NTH10/00230, CR2012/007476
Your ref: SSD 5204 (12/04216)

Exhibition of Tamworth Hospital Redevelopment (SSD 5204) – 31 Dean Street, Tamworth

David Bell
Regional Manager, Northern

**Figure 4: Proposed new right hand turn bays and roundabout**

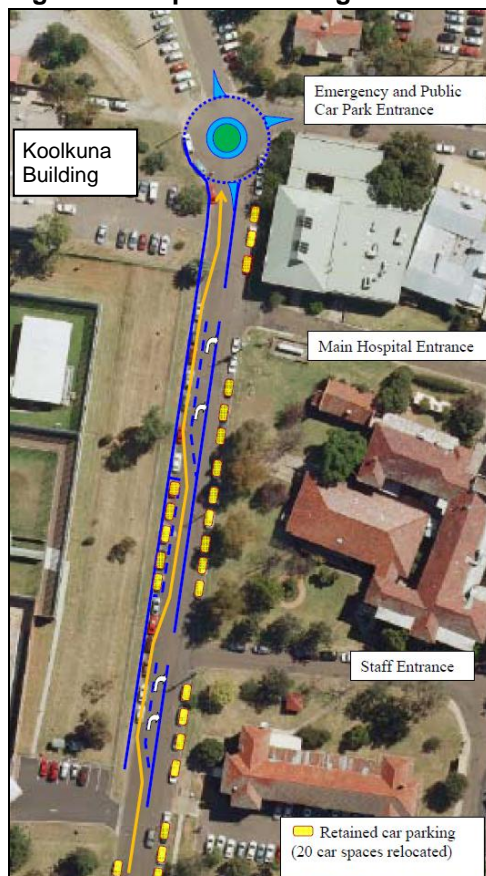
The proposed traffic management for Dean Street, as demonstrated in figure 16 of the ARUP report, has proposed the introduction of two right turn bays on Dean Street to facilitate access to the main entrance and staff entrance. RMS recommends that this arrangement be reconsidered in favour of introducing a central median that restricts right turn movements and directs traffic to circulate via the proposed new roundabout.

**Figure 5: Redundant vehicle access points to be closed**

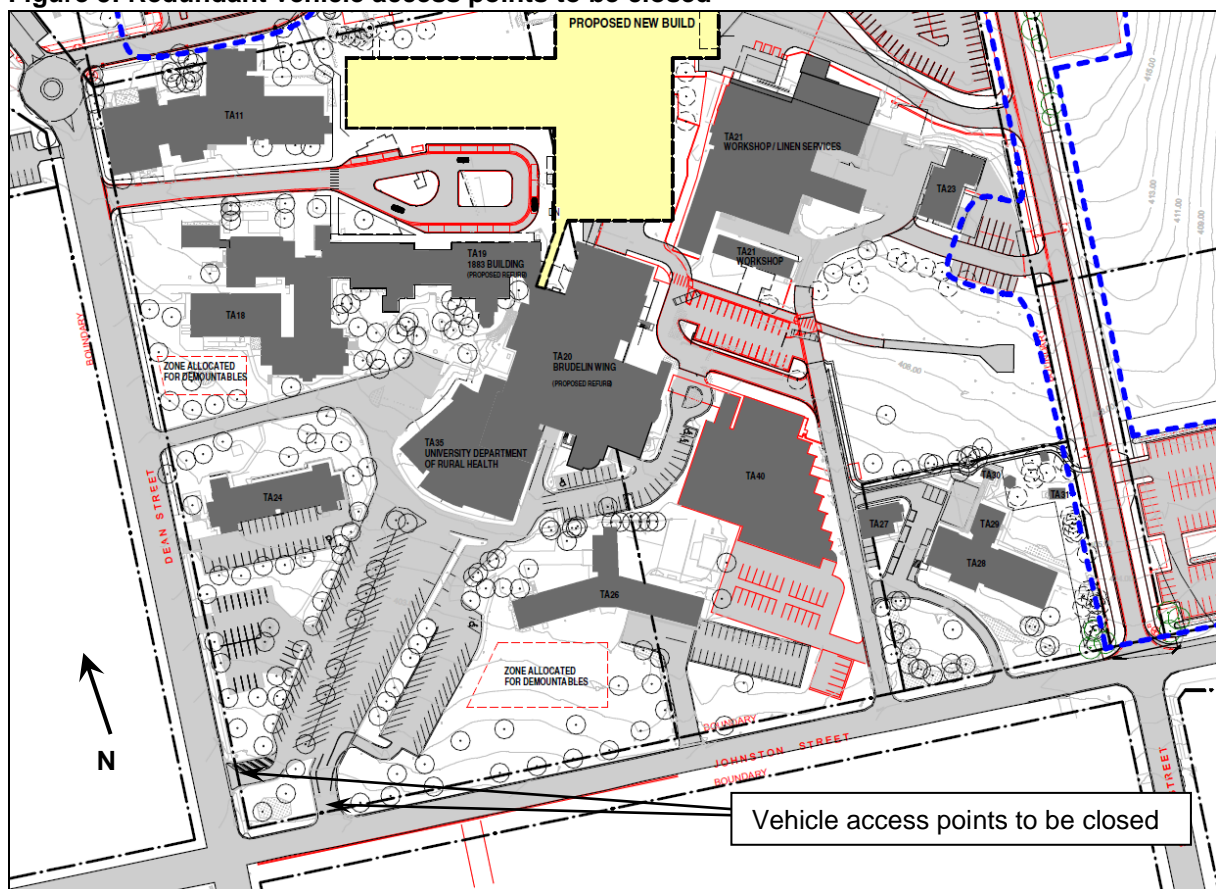
The Hospital currently has six existing access points along Dean Street. It is recommended that the redevelopment consider rationalising access points in the vicinity of the Dean Street – Johnston Street intersection by providing improved internal connectivity, which will reduce conflict points. Additionally, the existing access to the 'Koolkuna' Building, directly opposite the main access, could be closed and relocated to form a western stub of the proposed new roundabout. The above recommendations will assist in the retention of existing on-street car parking spaces along Dean Street and may potentially result in additional supply.

**Figure 6: Emergency vehicle access arrangements**

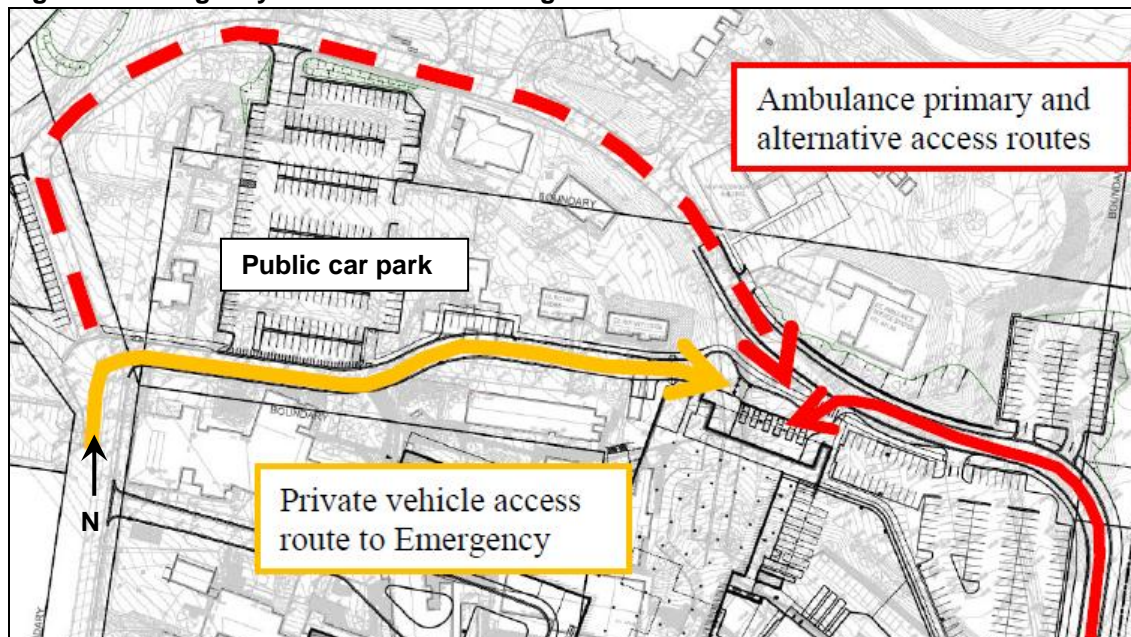
The most direct access route for ambulances to approach the hospitals 'Emergency' is along Dean Street. The arrangement shown in figure 18 requires ambulances approaching the hospital to deviate around the ring road to reach emergency, which appears to be a longer path than that indicated for private vehicle access. It may be feasible to allow ambulances to approach along the private vehicle route and provide a barrier gate at the terminating cul-de-sac rather than travel the additional distance around the Ring Road as demonstrated by the dashed red line.
